Please ask for: Mrs D Johnson
Email: daun.johnson@arun.gov.uk
Telephone: 01903 737762
Our Ref: Y/18/21/RES
Your Ref:
Date: 23rd February 2021

Application for Approval of Reserved Matters Following Outline Approval

Development: Approval of reserved matters following Y/62/18/OUT for 33 No. residential units, access, landscaping & associated works. This site is in CIL Zone 3 & is CIL Liable as new dwellings.
Location: Clays Farm North End Road Yapton BN18 0DT

Project	Clays Farm, Yapton		
Drawing	House Type A30L Floor Plans		
Client	Aster Group		
Job no.	ASTE200629	Date	Jan'2021
Dwg no.	HT.A30L.p	Rev.	A
Author	MS	Checker	AS
Status	PLANNING	Scale	1:100 at A3
Client ref.		Office	Romsey

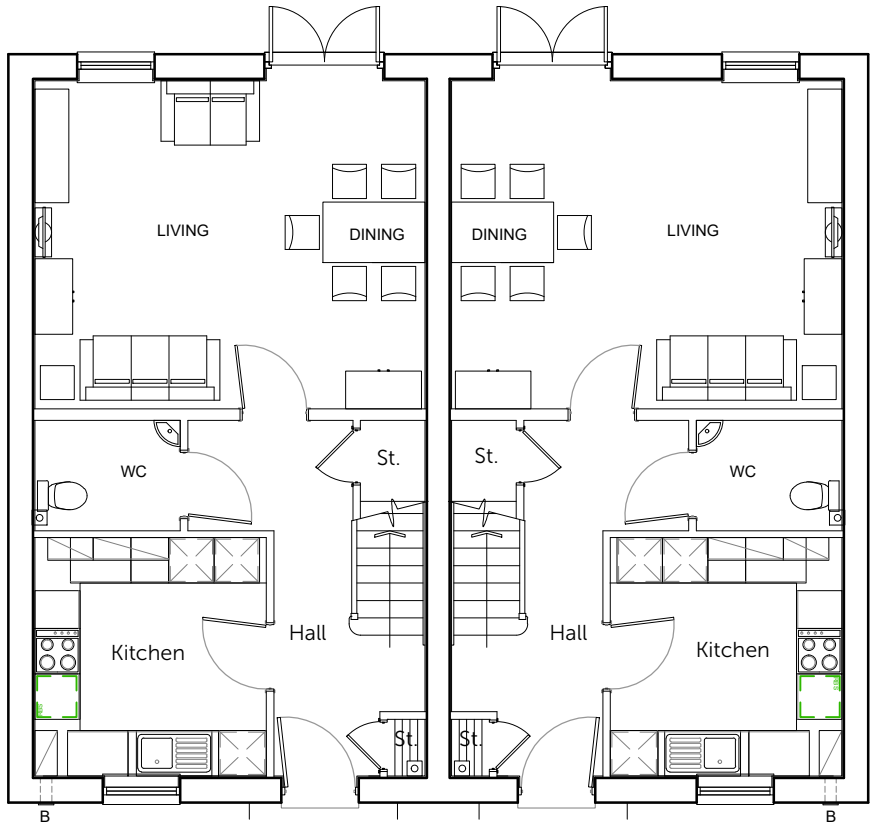
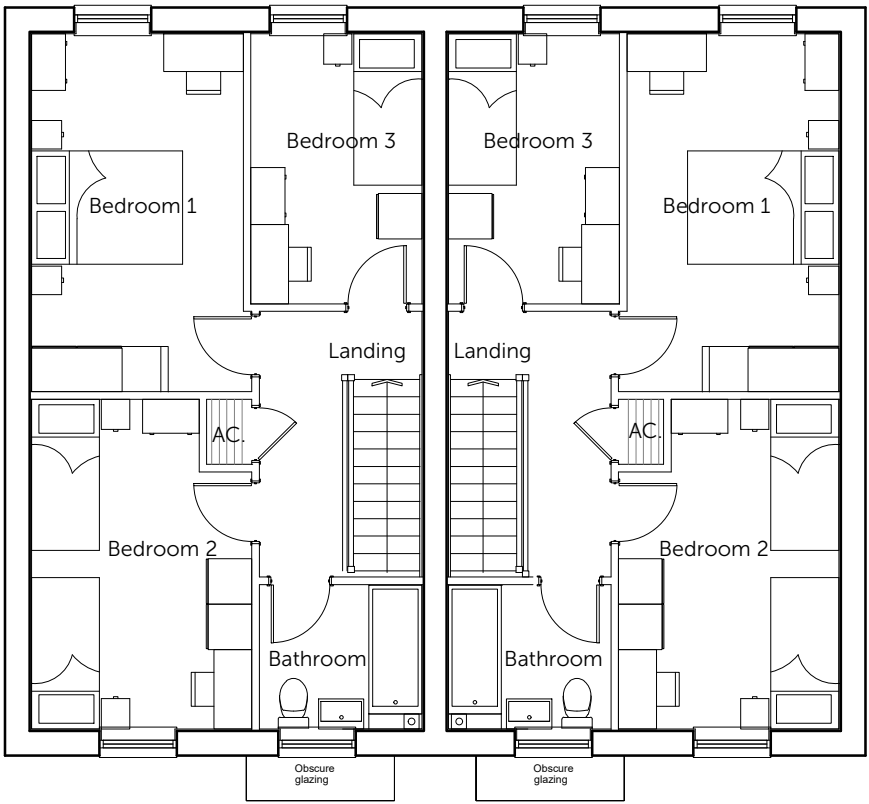
The plan for plots 8-9, 14-15 & 28-29 the rear elevation and ground floor plan do not accord. Please amend accordingly.
